We would like the Council to refuse this planning application ref **20/01897/FLH** and object for the following reasons:

Jennifer Courtney & John Young  
Executors of the deceased, Mrs Florence Young, of 9 Cudas Close, Stoneleigh, Epsom, KT19 0QF.

Proposed Floor Plans

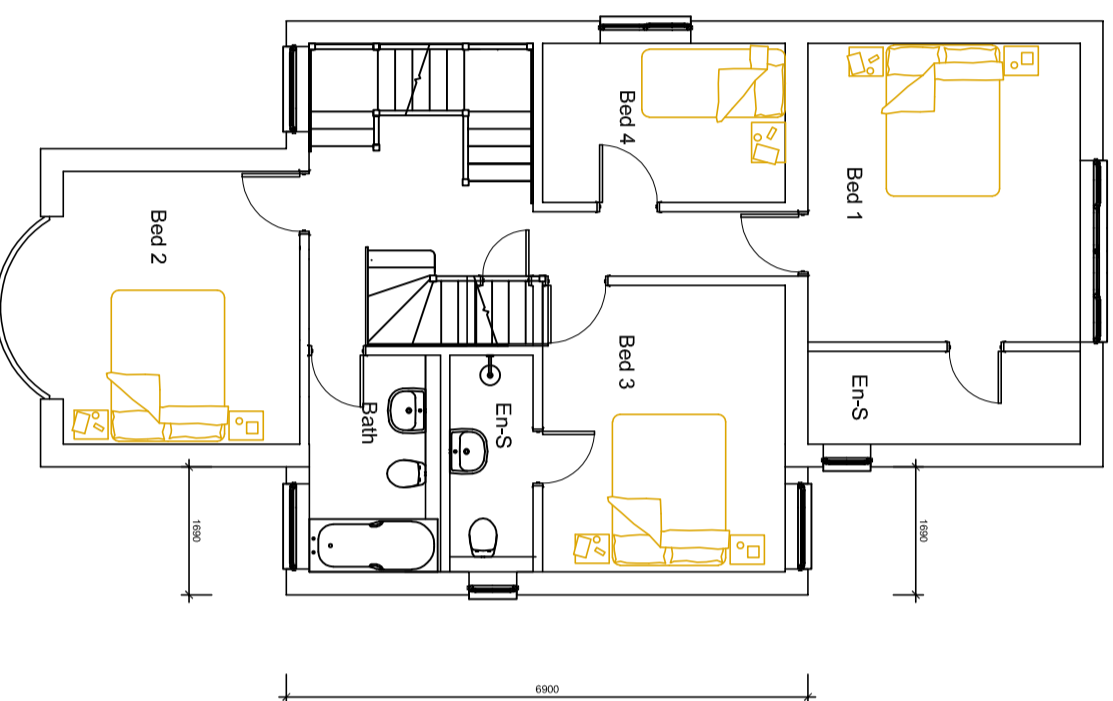
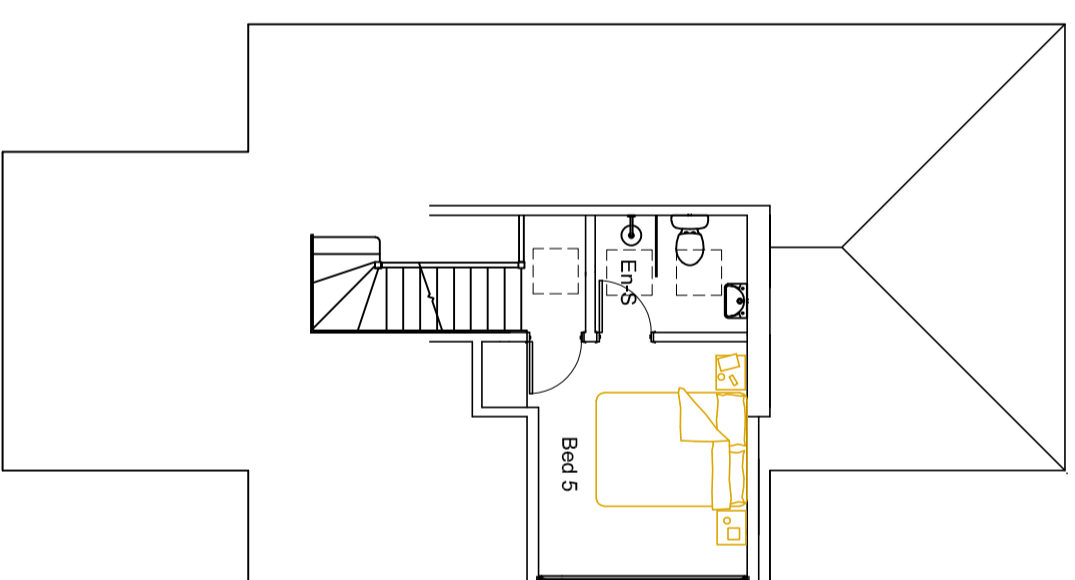
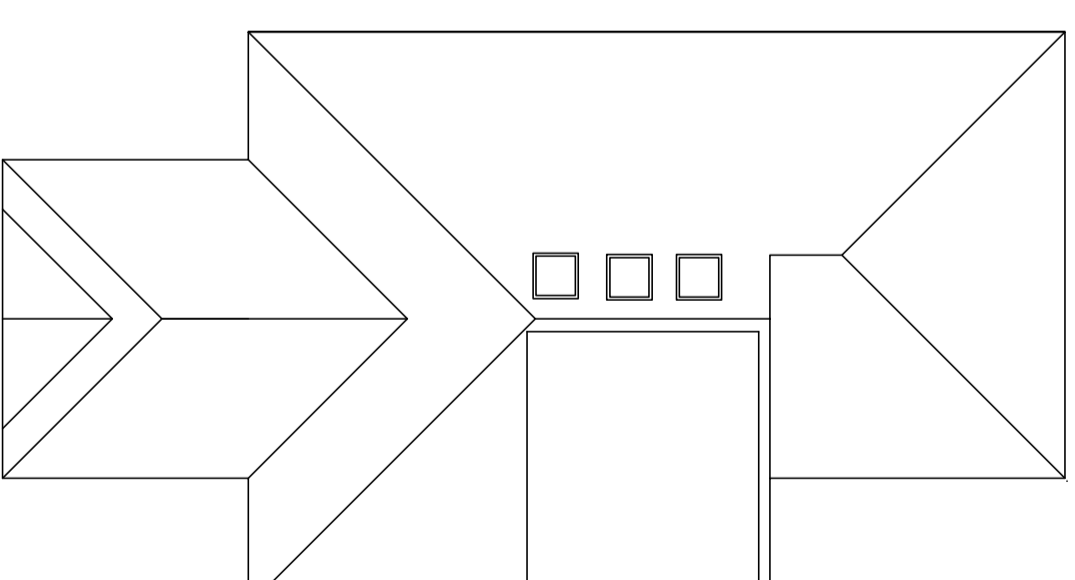
(i)clause 3.4 which states 'The aim should be to set back the wall beside the side boundary at least 1m throughout its height, up to the eaves'. Currently the proposed extension is less than 500mm.

Proposed Elevations

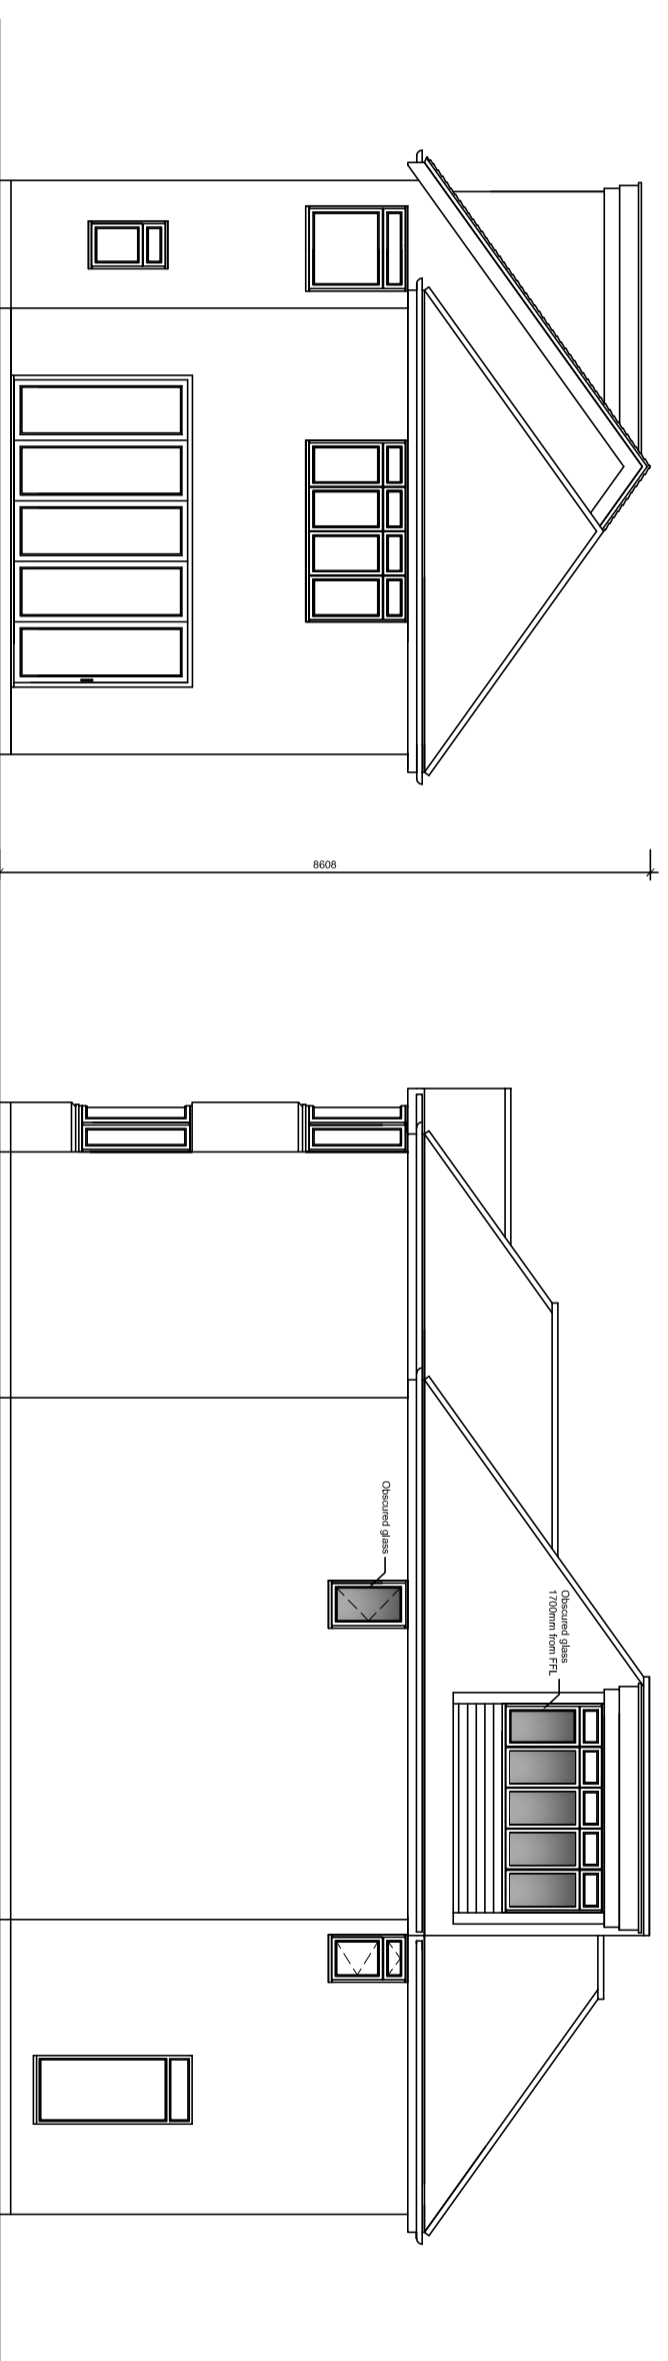
Generally - Dormers should not normally be introduced on the front or side elevations, to maintain street character. This proposed dormer is in the side.

4.1 Generally, these should only be used on rear elevations. This application proposes a dormer on the side.

4.6 To protect privacy, there should be no balconies or full-height windows, and side windows should be discouraged. The windows are full height.

4.12 They should be kept below the house ridge line by at least 0.5m. The flat roof of the proposed dormer is approximately 600mm higher than the house ridge line.
